Addendum to Technical Support Document #3

**AIR QUALITY & ODOUR ASSESSMENT**

## 1.0 BACKGROUND

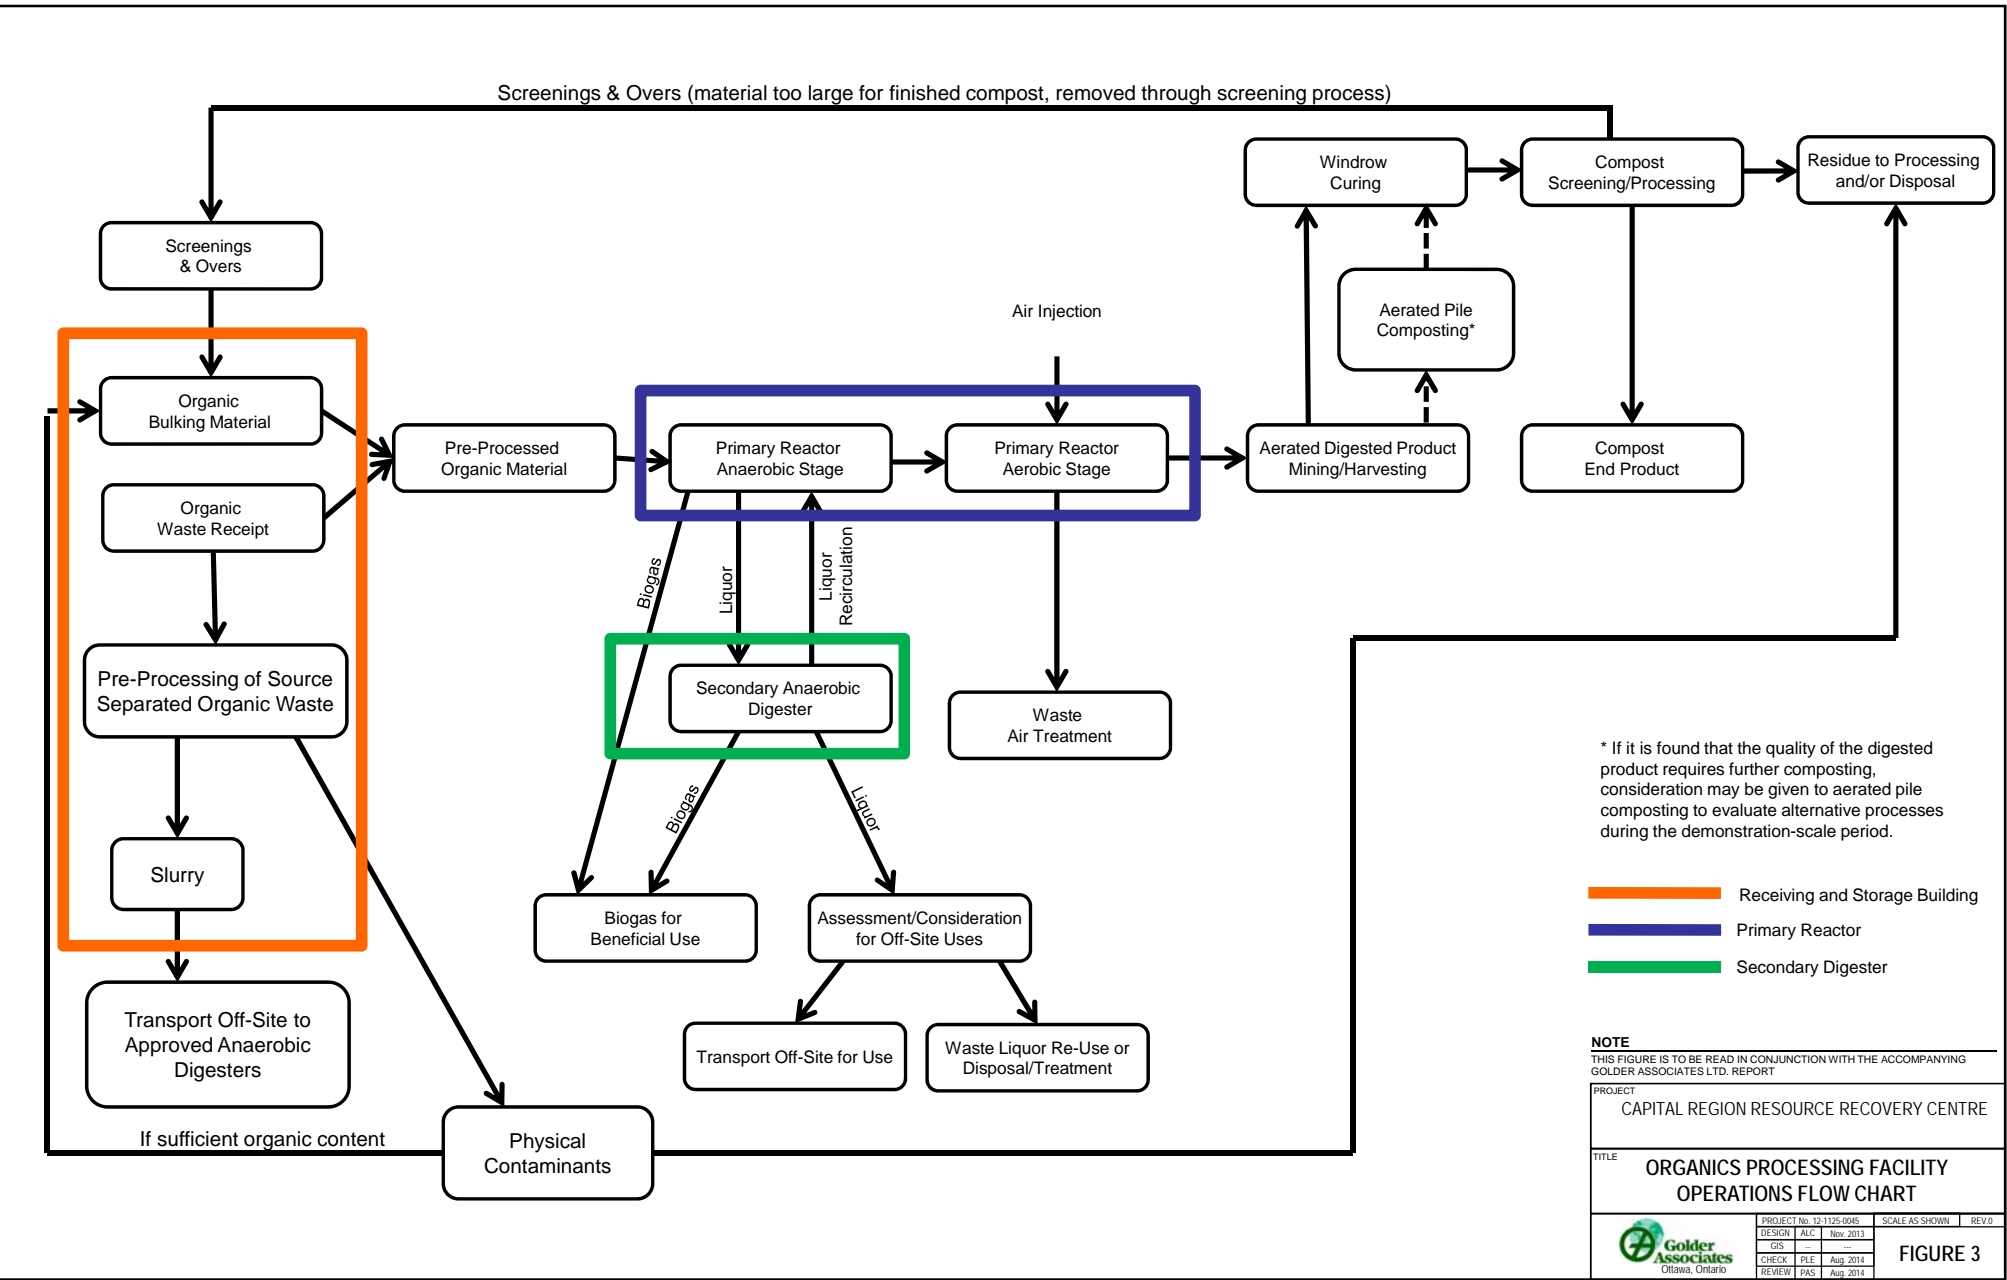
The primary reactors have been designed with a triangular cross-section, as per Appendix G Figure 2 in Volume IV, of 70 metres across with 5.25H:1V slopes to a peak height of 7 metres. Every 1 metre length of the reactor corresponds to a volume of 245 cubic metres, or about 1 day's placement. Because it would be impractical to build the cell in 1 metre strips, it was assumed the mixed organics would be placed over roughly half the cell width (35 metres) to the final shape (volume of approximately 123 cubic metres/metre): this would require a cell length of about 1.7 to 2.3 metres, which is something that could be built with a loader, but more likely would be approximately 3 metres wide. As such, the available daily quantity would not enable the cell to be built to its final shape in a single day. At 3 metres wide, the corresponding footprint area (odour source area) would be about 90 square metres. Compared to the landfill working area odour source area of 1,500 square metres, this is about 6% of the landfill source area.

Comments 7, 8, 9 & 19 are mainly addressed in the updated odour management plan memo contained in Appendix A of this addendum. To complete the response to comment 19, a primary reactor odour source was added at the organics processing facility location. For odour modelling purposes, 5% of the size of the landfill odour source area was used as the primary reactor odour source area. The rationale for the use of 5% is described below.

The organics processing is to take in 50,000 tonnes per year; at 312 operating days/year, this equates to 160 tonnes/day. The organics mixed with bulking agent will be moved and placed in the primary reactor cell during the latter part of each operating day at a rate of about 70 tonnes/hr. It has been assumed that the "latter part of the day" is 3 to 4 hours out of the 12 hour day, which means that 210 to 280 tonnes/working day of organics mixed with bulking agent is moved and placed in the primary reactor. This is the material that represents the odour source for the modelling. It was also assumed that the weight of wet food waste is approximately 1 tonne/cubic metre, which corresponds to 210 to 280 cubic metres per day of airspace in the primary reactor. Each primary reactor cell is 70 metres wide x 300 metres long in plan area.
